Our Ref: M/82/19/HH

Development Two storey side extension, single storey first floor side extension and addition of 2x side dormers, and 1 x front, 1 x rear dormer.

Location 6 Main Drive Middleton-On-Sea

PROJECT NO.
PA-314-04
DRAWING TITLE
Proposed Site &
Location Plan

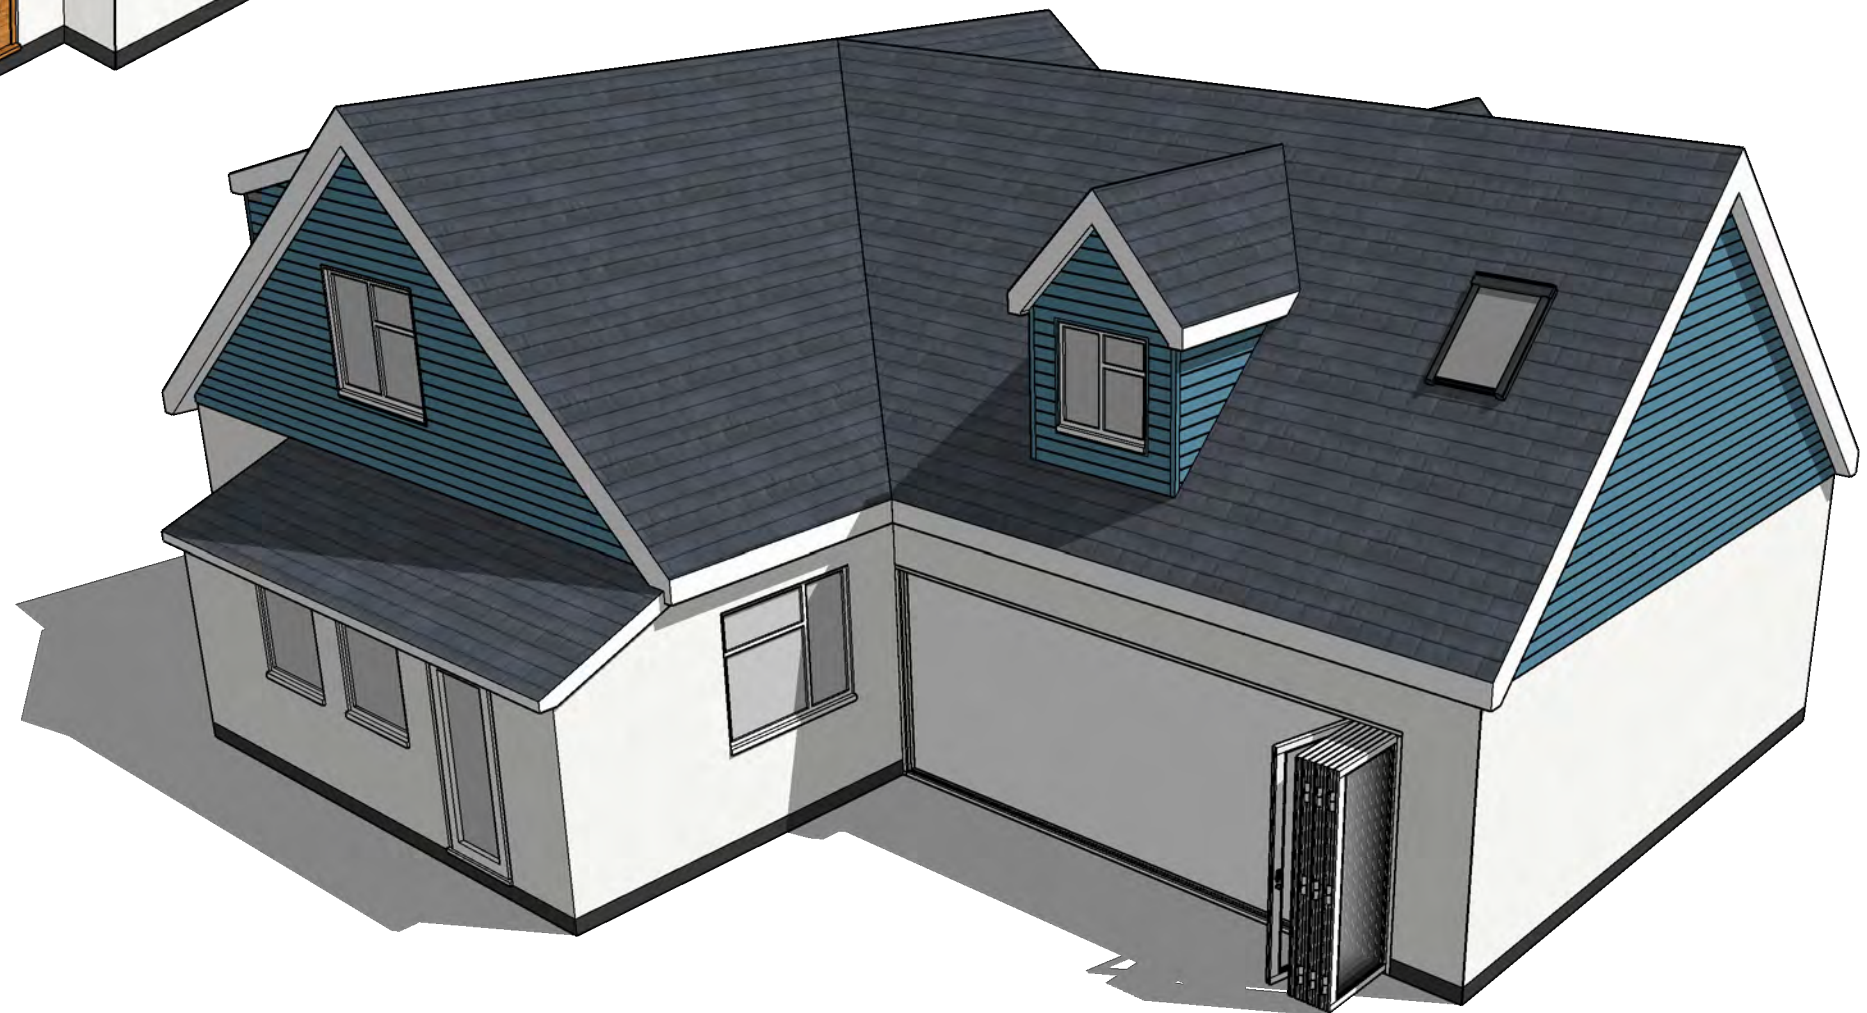
Block Plan

You are required to submit a block plan which includes dimensions from the proposed extensions to all site boundaries.
